SSD-9176048: Tomingley Gold Extension project

TfNSW have reviewed the Integrated Transport Assessment prepared by Constructive Solutions dated December 2021 and require the following additional information to continue the assessment of the application:

Figure 1 – TGO Traffic Routes

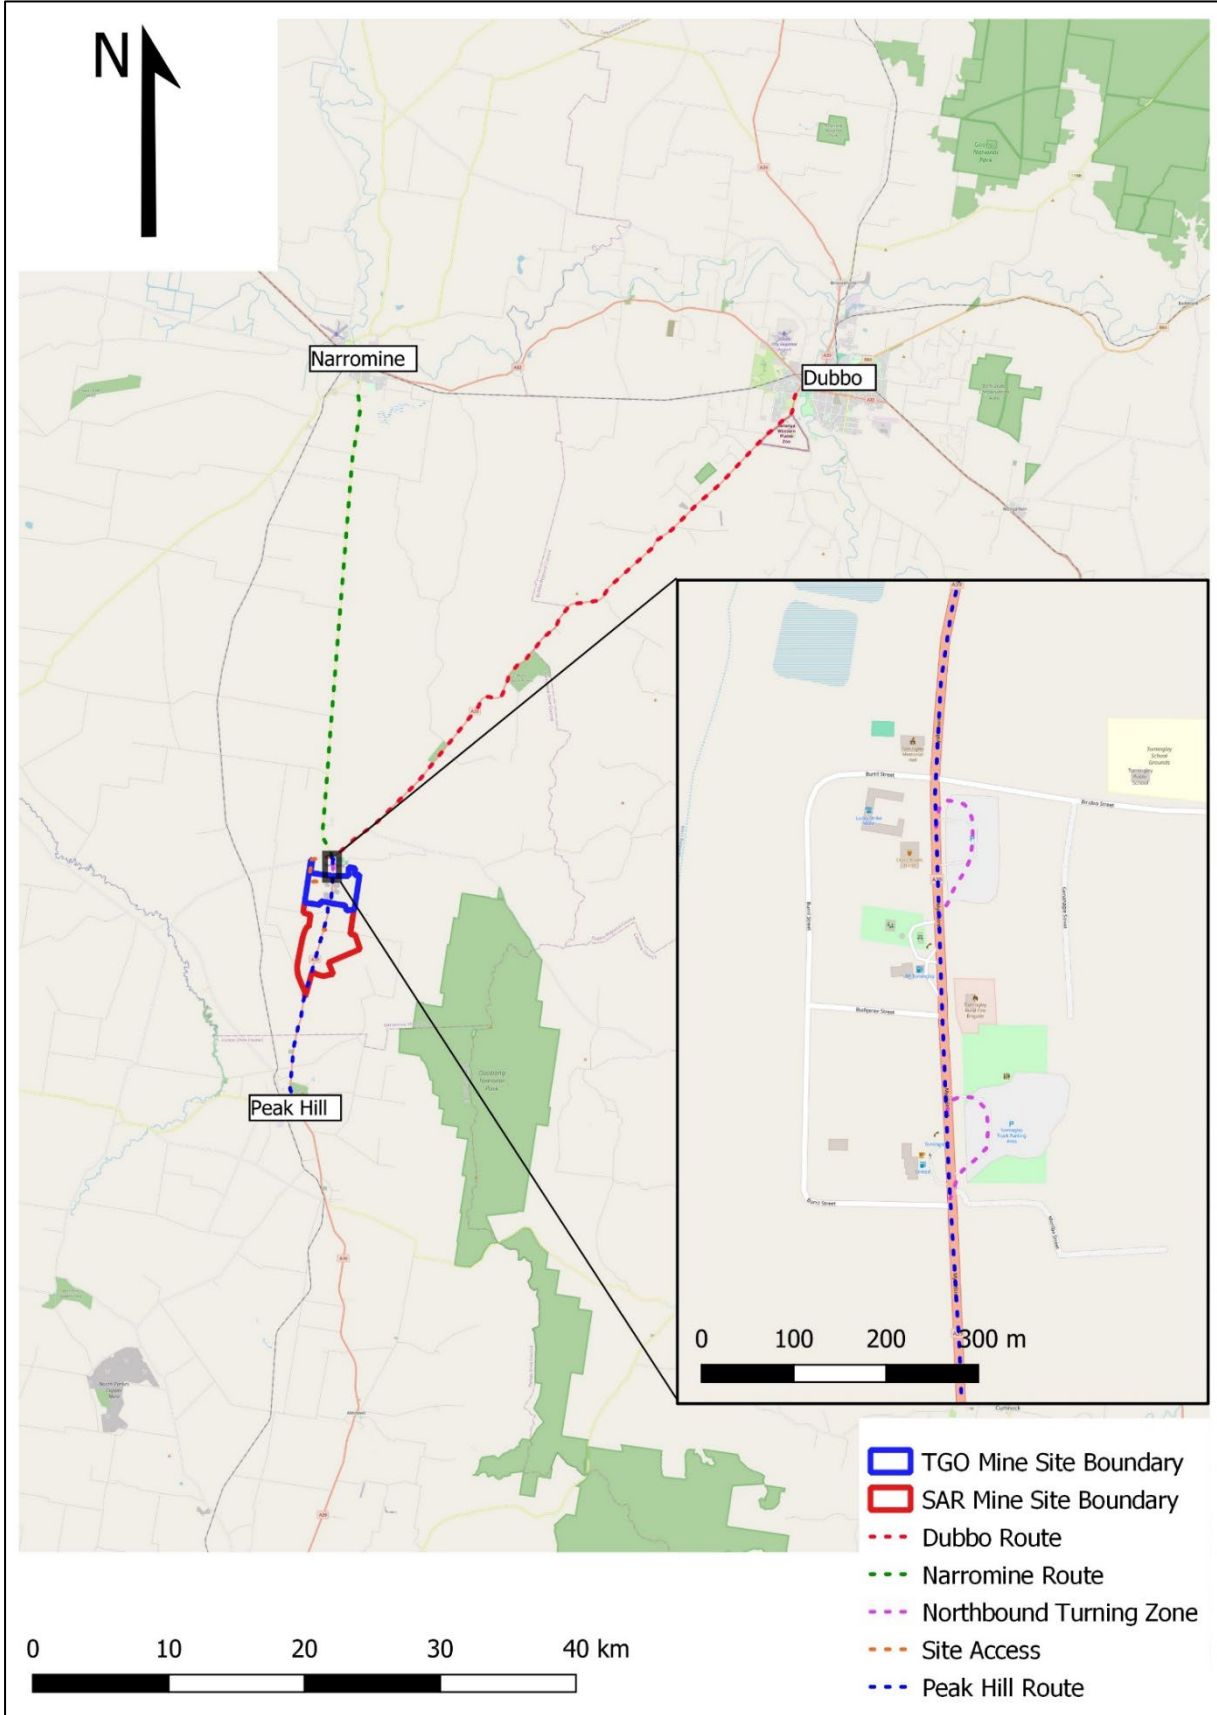
- Section 3.1.1 identifies the Heavy Vehicle Exit point 1 utilising intersection of McNivens Lane/HW17 and 2 utilising the HW17/Back Tomingley West Road intersection. There appears to be no mention of ingress for heavy vehicles or the heavy vehicle design vehicle.

- **Section 4.1.1- Heavy Vehicles-**It is noted that there are no haulage routes identified on public roads. However, it is unclear from this section the proposed haulage routes for the operation of the development.

- **Section 4.1.1- Heavy Vehicles-** This section does not identify the haulage routes for heavy vehicles or OSOM deliveries during construction.
- **Section 4.3.3- Land swaps-** It is noted within this section that land swaps to create the road corridors through the process of subdivision will commence on completion of the 100% concept designs acceptance by TfNSW and NSC. There is a risk to the proponent and the project of the commencement of this process prior to the approval of the Tomingley Gold Mine expansion.

Figure 2 – Nearby Bus Routes

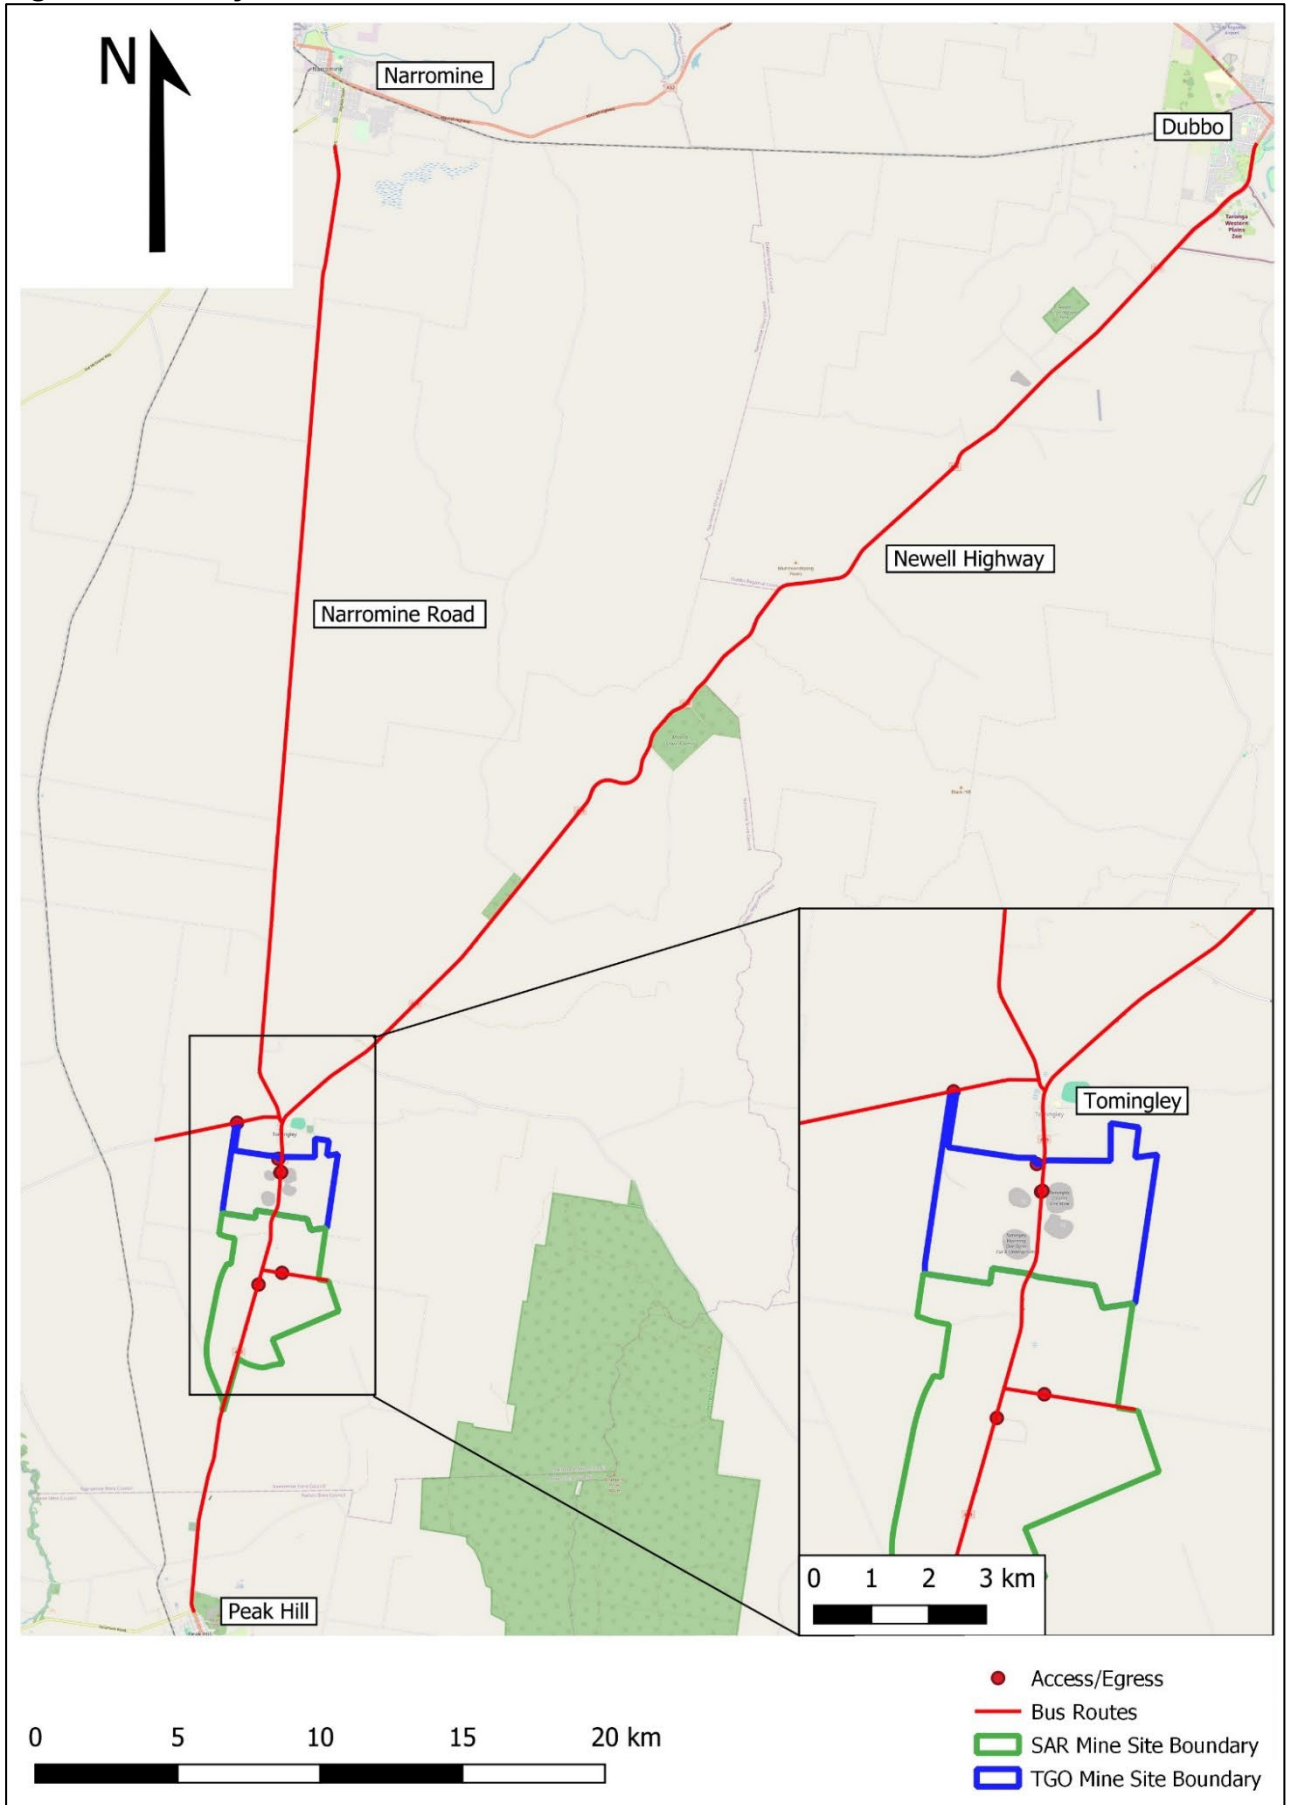
- **Section 2.5-School Bus Services-** identifies that school buses run along Kyalite Road, Back Tomingley West Road, Tomingley West Road which are likely to be impacted by the proposed realignment and the operational phase of the Tomingley Gold Mine expansion. No information has been provided as a part of the ITA as to how the impacts of the realignment will be mitigated or minimised throughout the different stages of construction of the Tomingley Gold Mine expansion.
